RE: Ivin Boundary Line Adjustment, BL-10-00044

Map Number 23-14-35030-0011 Parcel Number 871635
Map Number 23-14-35030-0012 Parcel Number 881635

TO: Jeff Watson, Community Development Services
FROM: Christina Wollman, Planner II *W*
DATE: June 28, 2011
SUBJECT: Ivin BL-10-00044

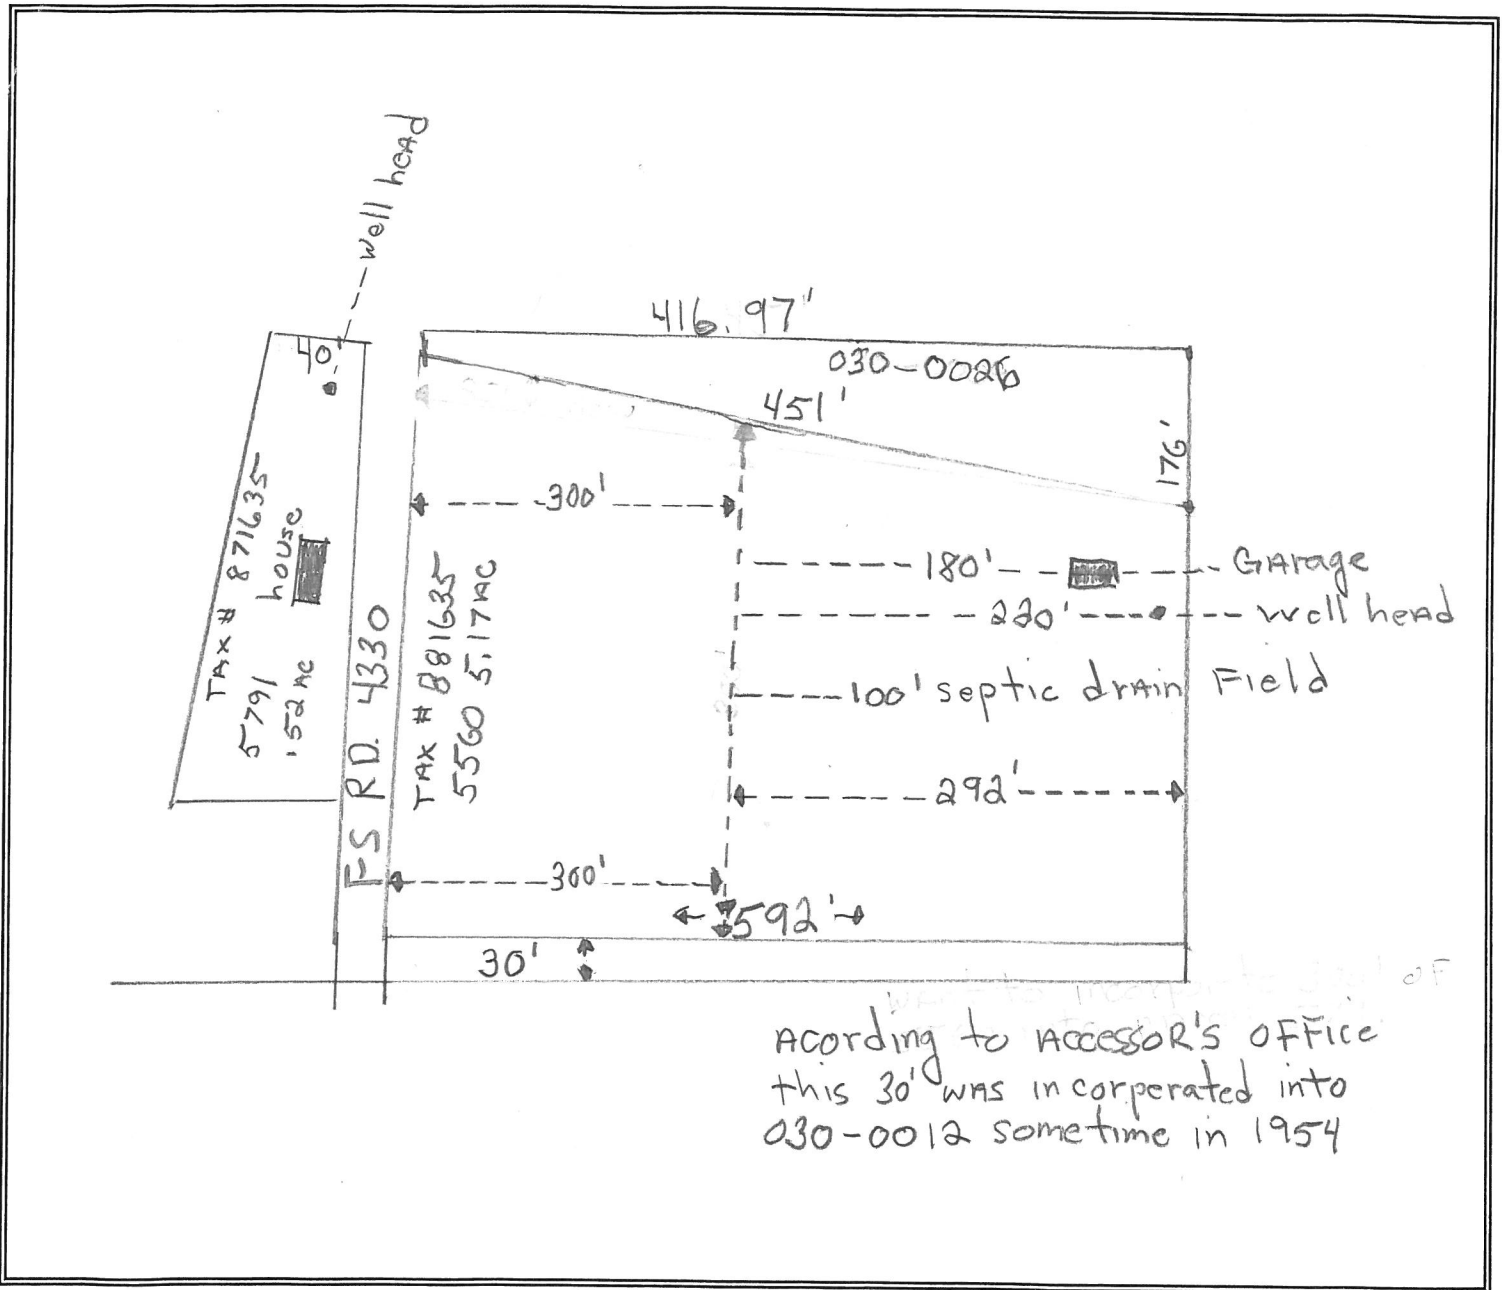
Looking at the site plan and the parcel configuration it appears to me that the well is forty feet from an adjoining property in different ownership (Henshaw) which is not part of the requested BLA. I don't think we are in a position to do anything about that within the context of this application but...? The other parcel's well head although no measurement is given, appears close to the east boundary, but again, not impacted by the requested alteration. Let me know what if anything can or should be done...

I have some questions on this one. It appears that the well(s) may not be 50 feet from the property lines in this one.
